PORTLAND MAINE

June 3, 2011

RE: 54 Farnham Street – 310-F-010 – R-3 Zone

54 Farnham Plot PLAN

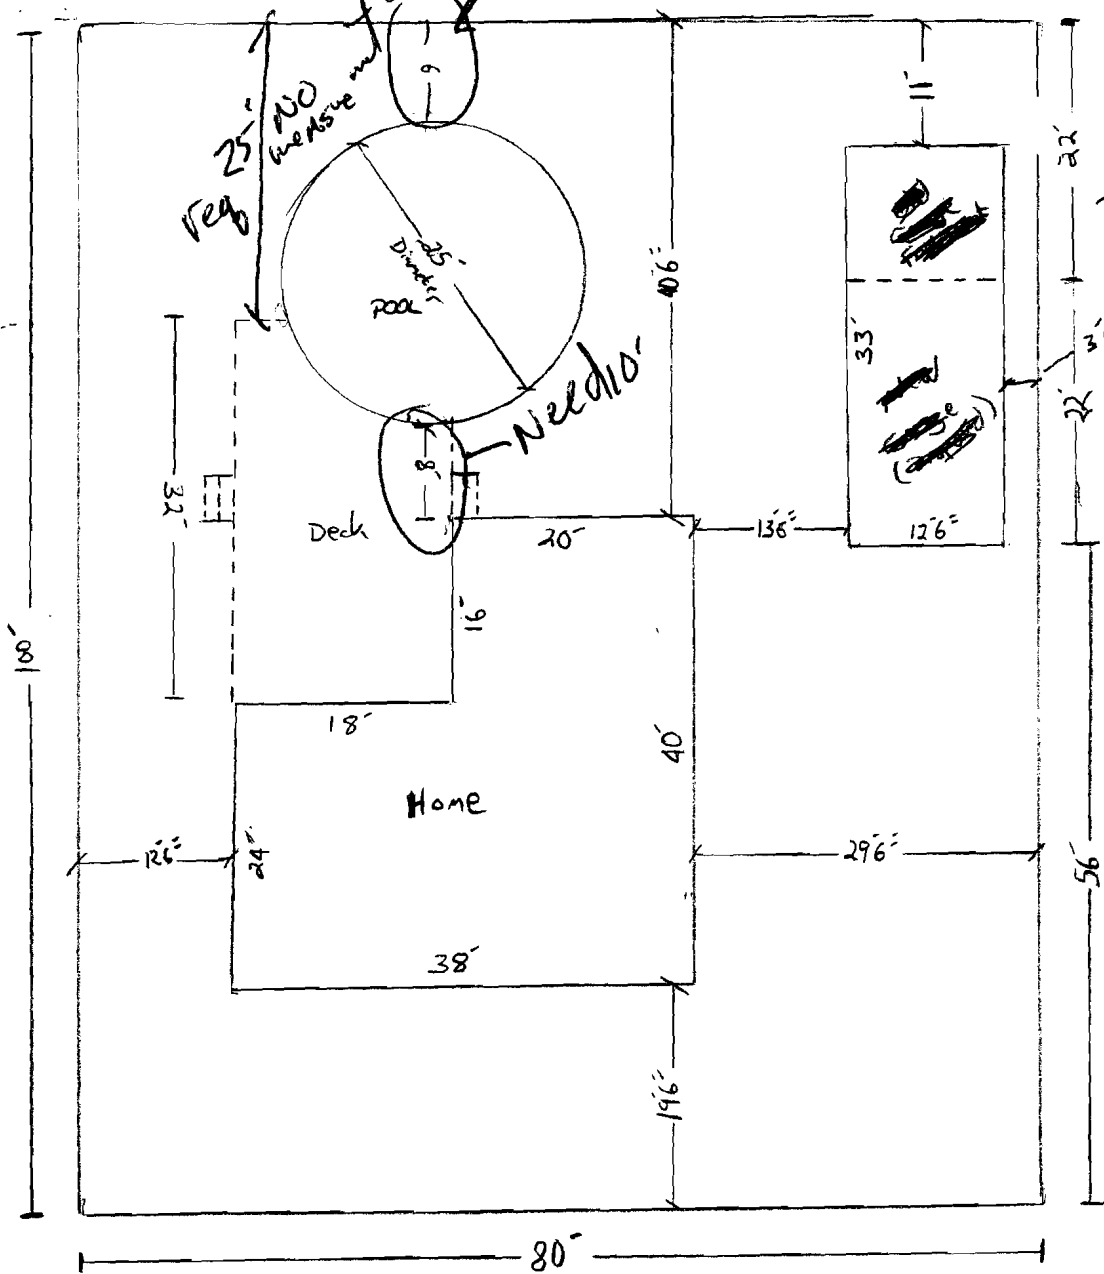
I am in receipt of a permit application to install a 25' diameter above ground pool with an attached deck. Your permit is being denied because the pool is not meeting the requirements of 14-432(b) which states: "No part of any swimming pool shall be located closer than ten (10) feet from the principal structure, nor closer than ten (10) feet from the side or rear lot lines."

The submitted plot plan for this application indicates that the pool is 6 feet from the rear property line and 8 feet from the principal structure instead of the required 10 feet.

If you choose not to appeal, you will need to remove the pool and/or reorientation the pool so that it meets the Ordinances. This office will need revised plans showing what changes you intend to make to bring the pool into compliance. Your property will be inspected within 30 days for compliance.
